CITY OF ALBUQUERQUE

August 27, 2018

RE: **La Pasada Addition**
2206 4th NW
Grading and Drainage Plan
Engineer's Stamp Date 8/20/18
Hydrology File: H14D089

Based on the submittal received on 8/20/18, the Grading and Drainage Plan cannot be approved until the following are corrected:

C-101

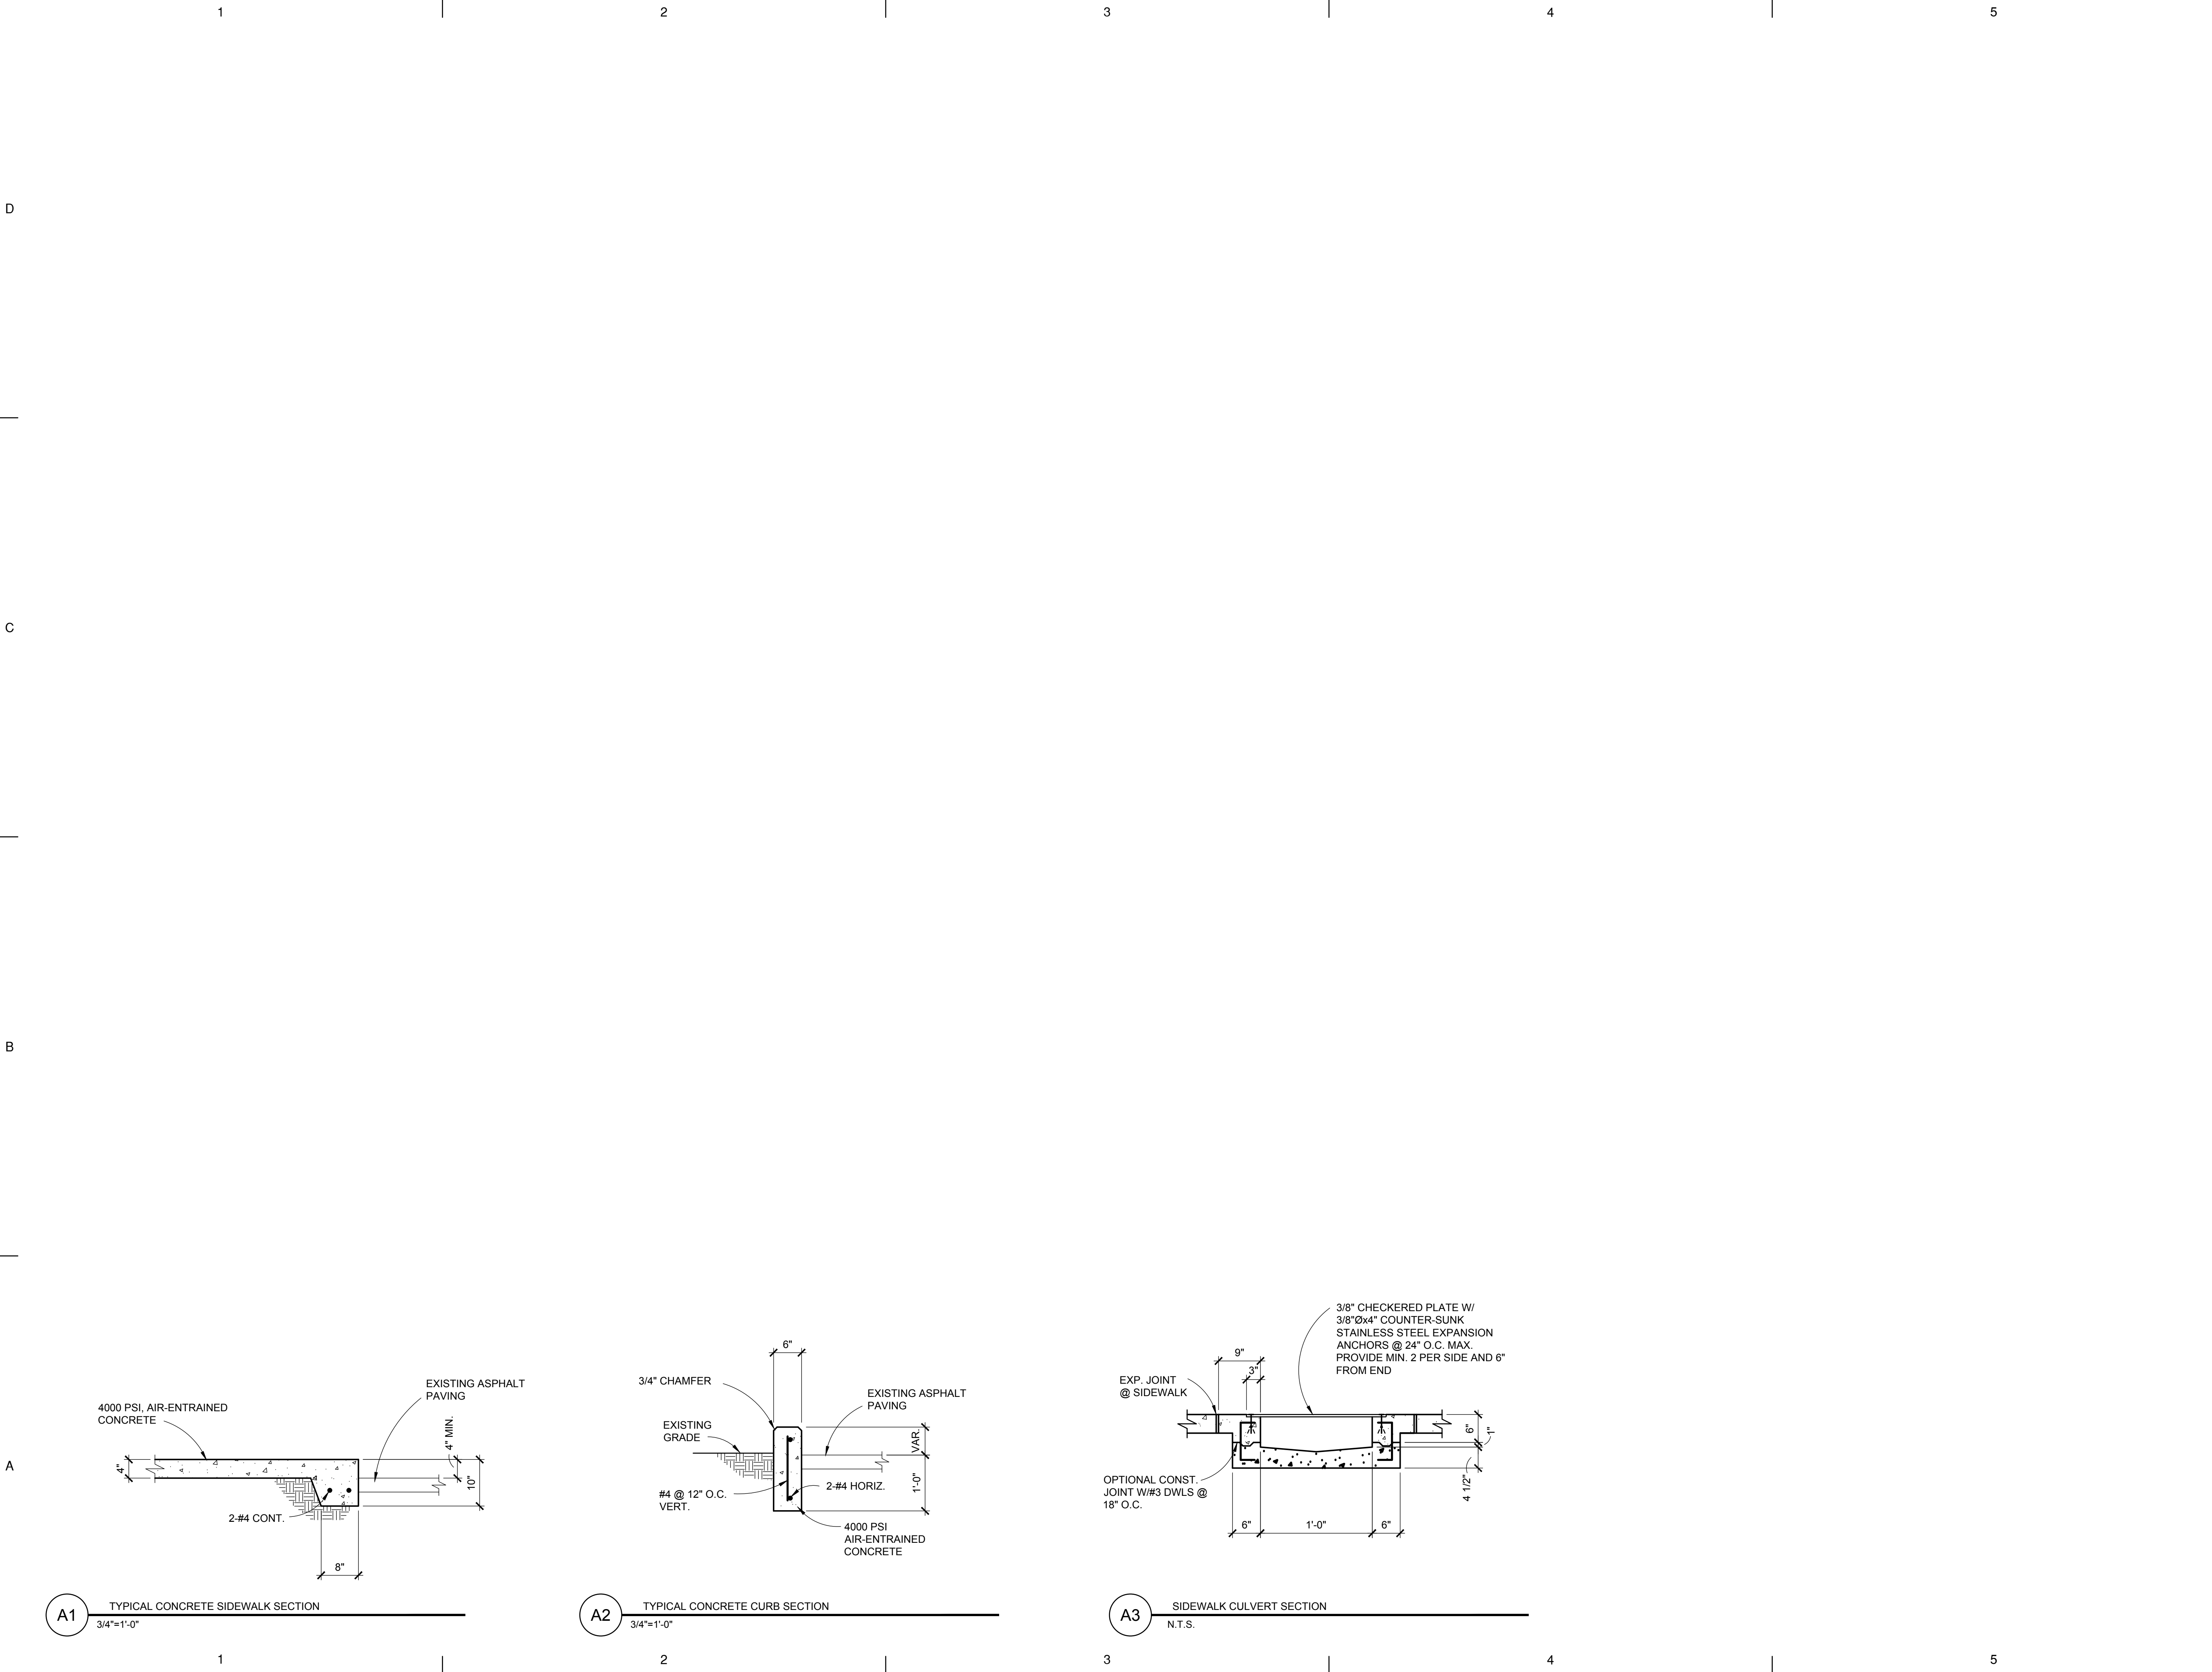
1. Payment of Fee-in-Lieu is required (Amount = 42cf x \$8/cf = \$336, per sheet C-101). Include the paid receipt in the resubmittal.
